KITTITAS COUNTY DEPARTMENT OF PUBLIC WORKS

MEMORANDUM

TO: Jeff Watson, Community Development Services
FROM: Christina Wollman, Planner II *CW*
DATE: August 20, 2012
SUBJECT: Armstrong BL-12-00017

The Public Works Department has reviewed the Request for Boundary Line Adjustment Application. In order to ensure that it meets current Kittitas County Road Standards, the applicant needs to provide the following prior to final approval:

33-81 KNUDSON SHORT PLAT Sheet 1 of 3

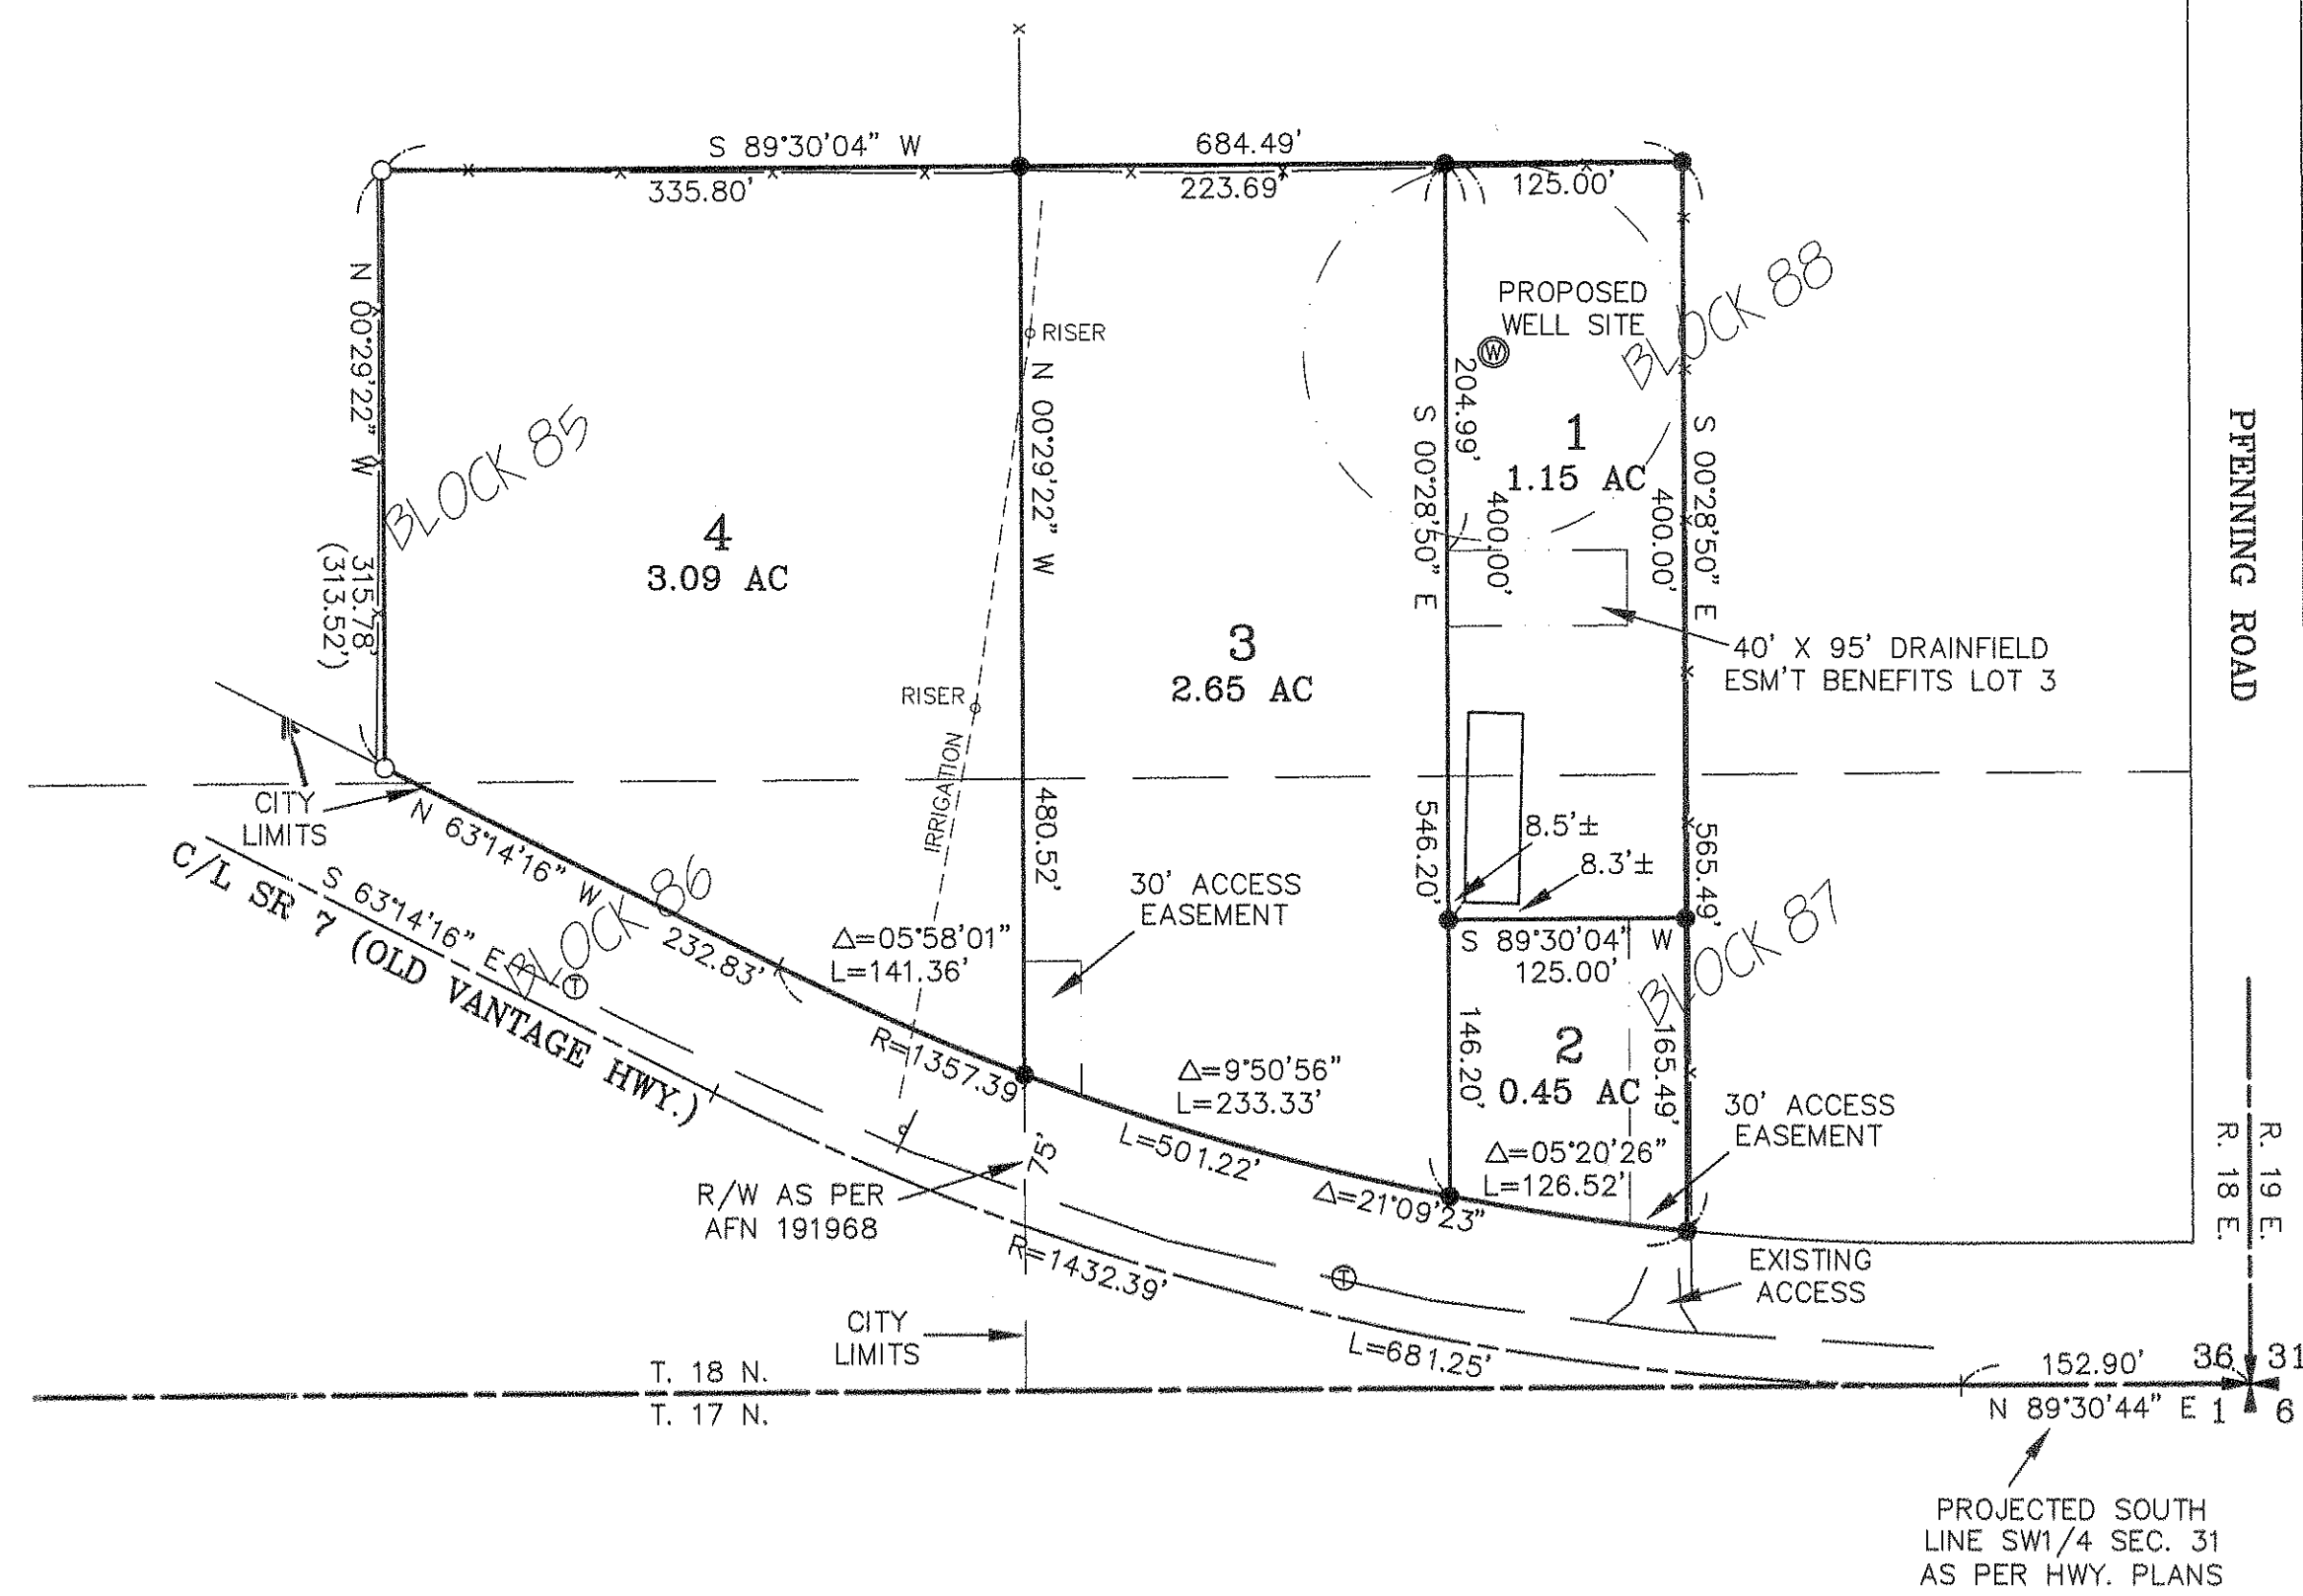
1. A revised legal description that describes the final configuration of the subject property shall be required.
2. **Legal access to Lot 1 shall be maintained, either through extension of existing easement or establishing a new easement.**
